**Consultation Response from KC,
Trees**

2023/91116 Land off, Primrose Lane, Hightown, Liversedge, WF15

Erection of 77 dwellings, with access from Darley Road and associated works

Date Responded: 26/04/2024

DRAINAGE STRATEGY

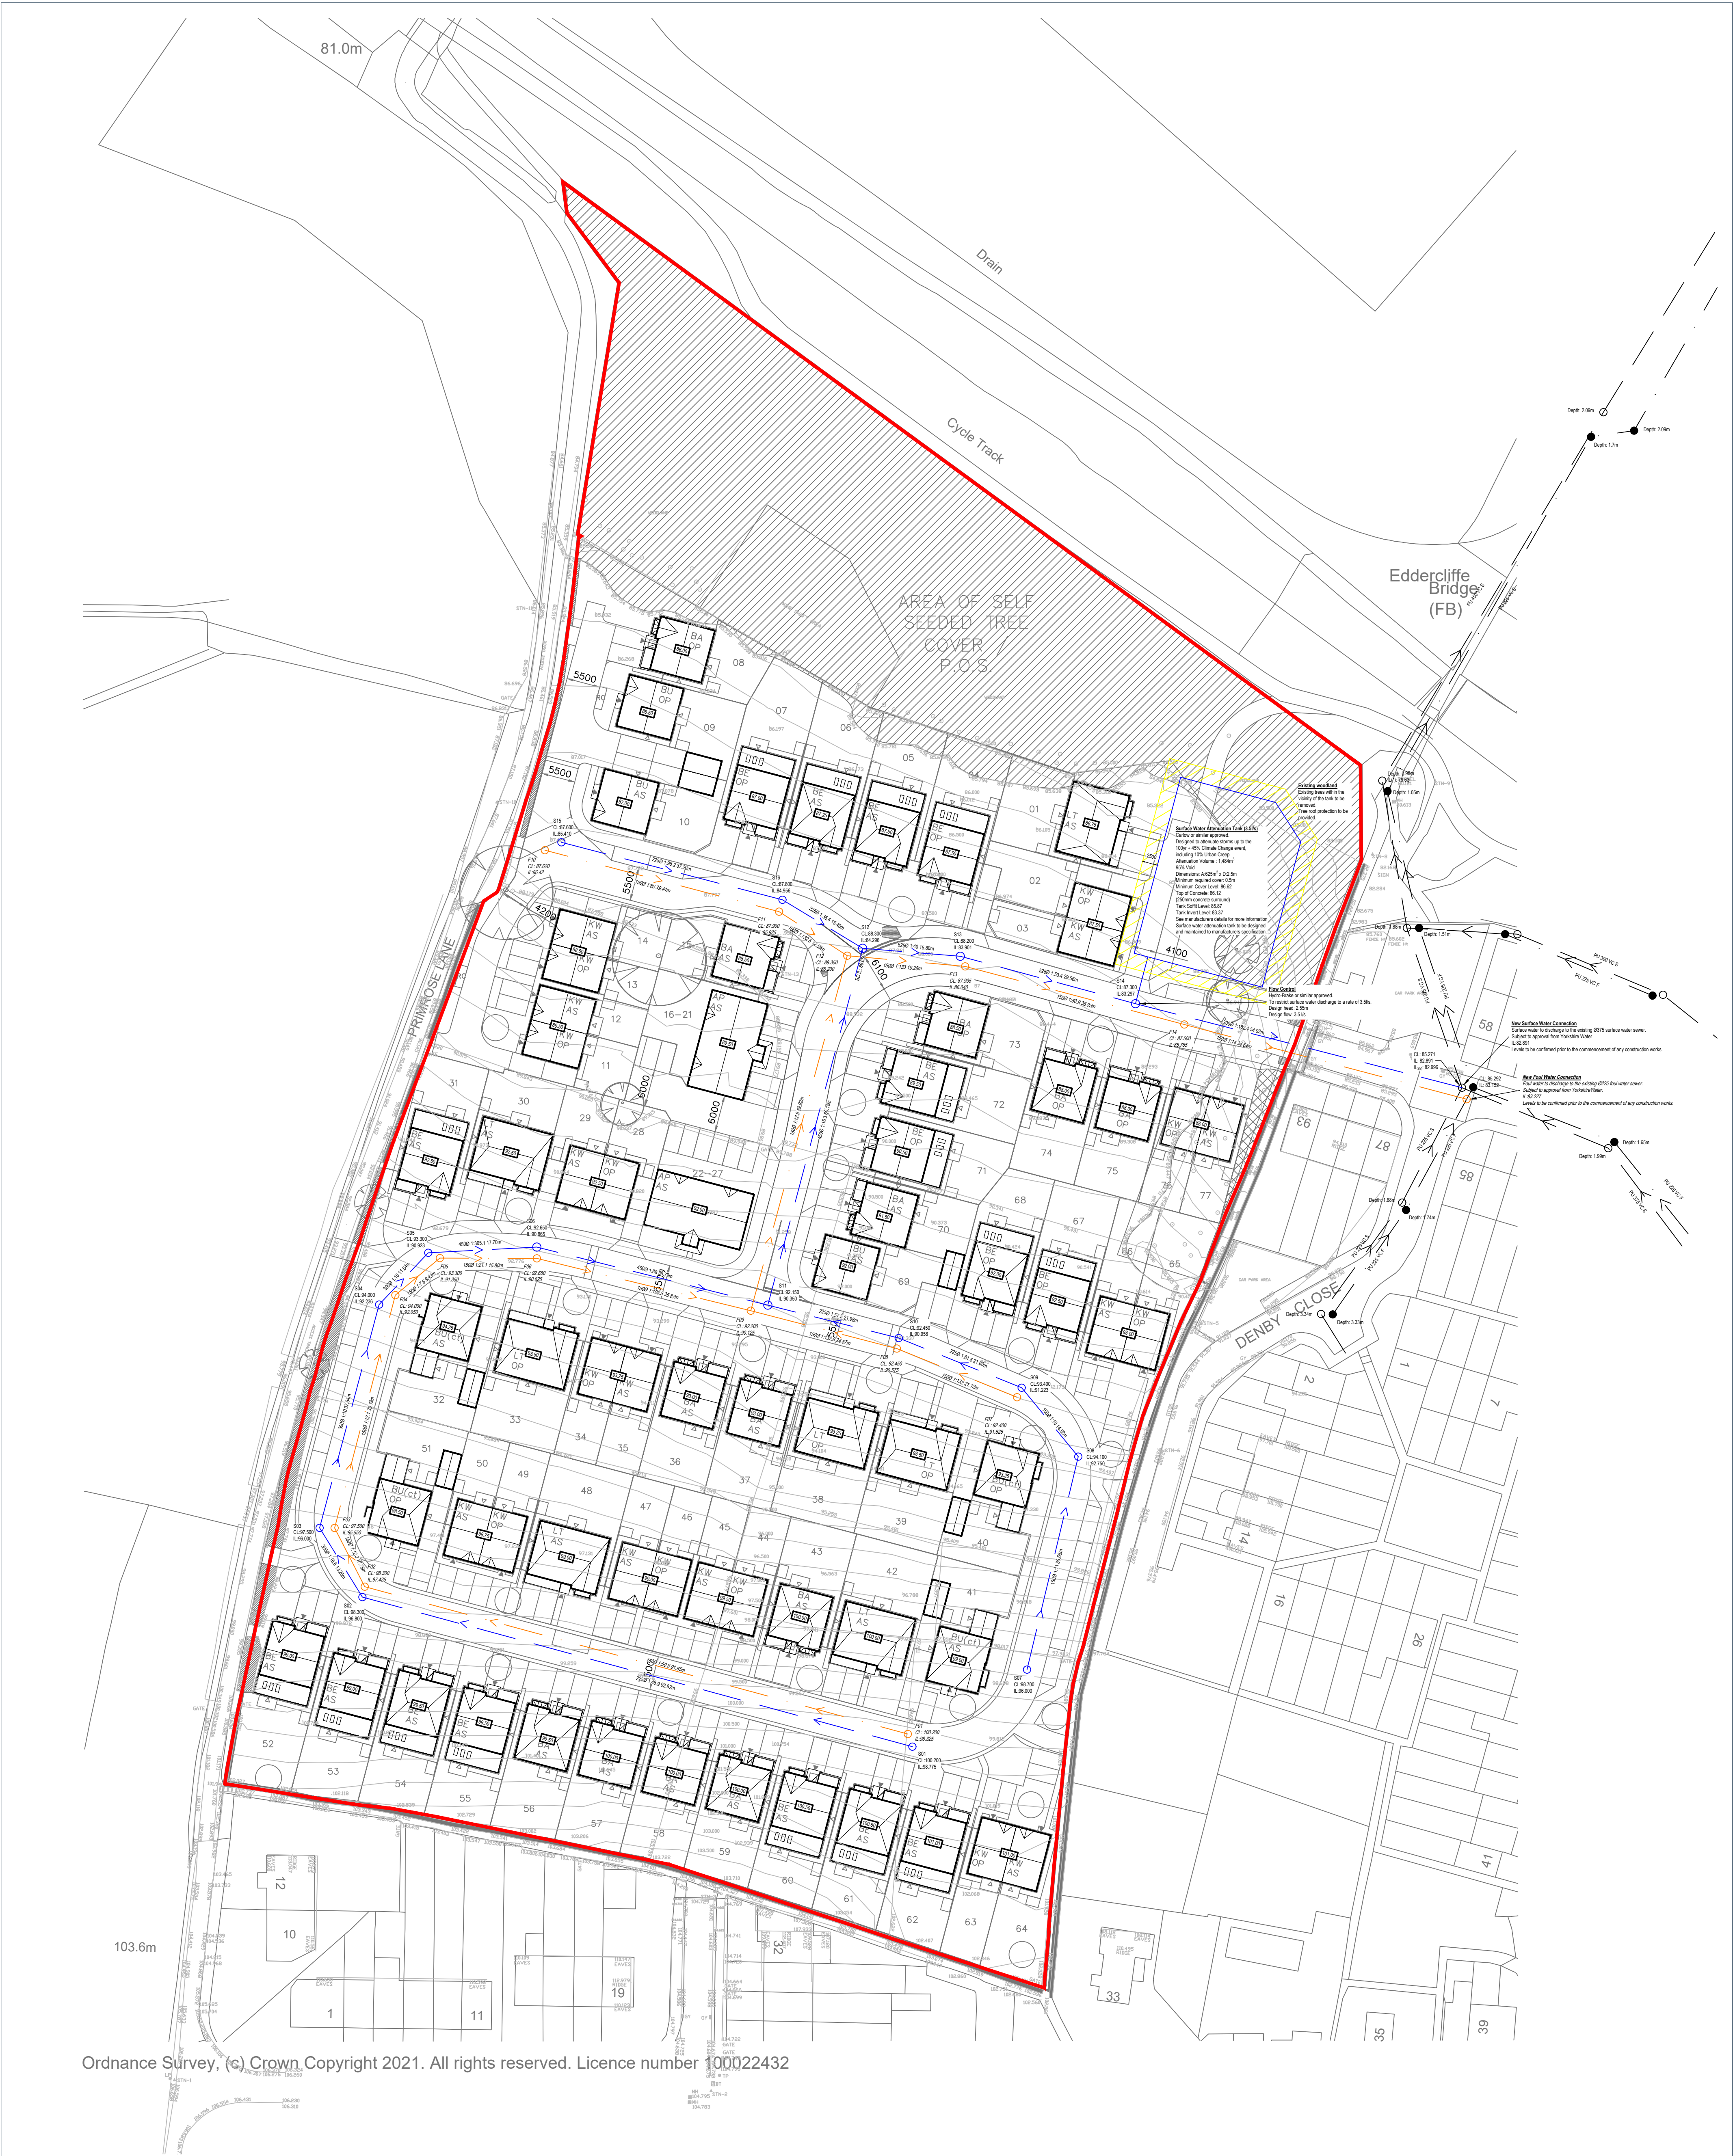
The Arb impact assessment (Ref: 21600-A/AJB) submitted doesn't consider/discuss the impact of the proposed easement that cuts through the woodland.

However, regardless it's not acceptable from a KC trees perspective that the easement cut through the woodland which is a high value arboriculture and landscape feature.
